From: Sue Howell
Sent: 14 June 2018 15:56
To: Planning.Responses
Cc: Andrew Wood
Subject: RE: Planning Consultation on: P/36/18/PL

Comment from Greenspace

Site Address: 30 Lagoon Road Pagham PO21 4TJ

Description of Works: Demolition & erection of 1 No. dwelling with
 associated vehicle hard standing area.

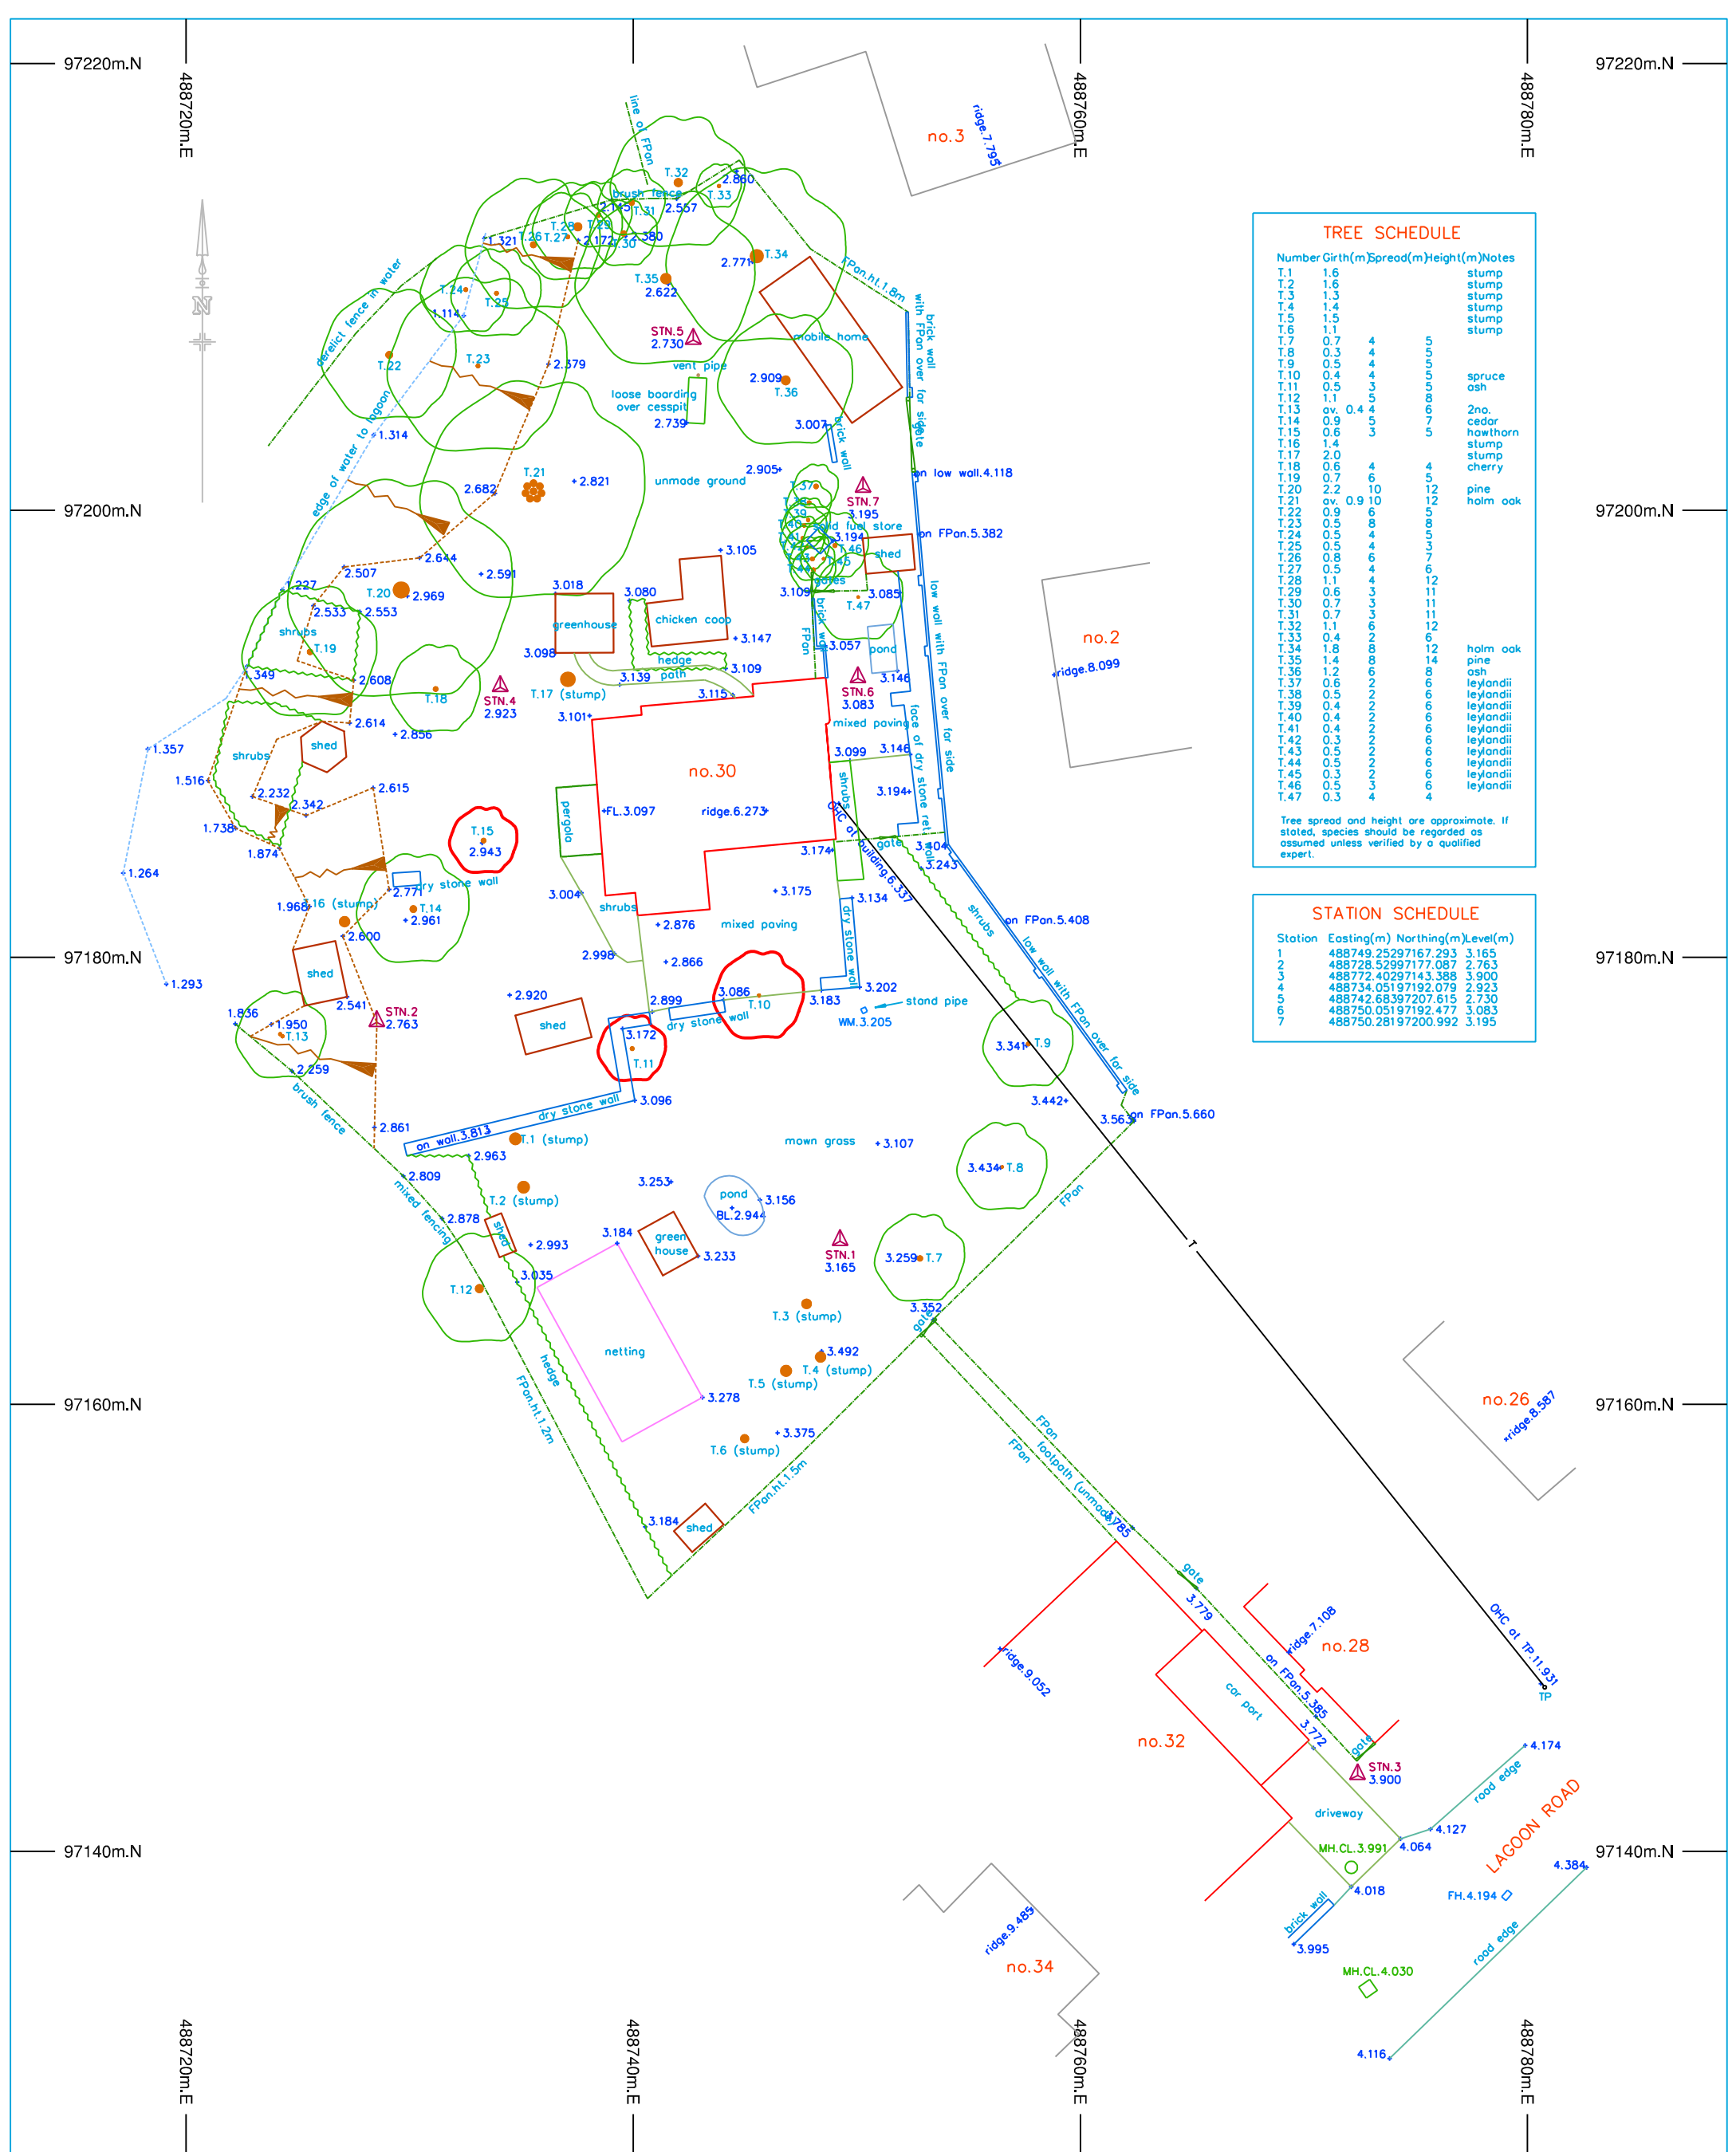
The existing vegetation to this site is established, these areas must be protected and retained. Detail would need to be submitted re tree retention and protection measures to be taken. Before construction, this tree protection scheme must be in place for all retained trees including trees whose root protection areas fall within the construction zone. This should be in accordance with BS 5837:20012 'Trees in relation to construction' Any tree removal must be in consultation with Arun District Councils tree officer.
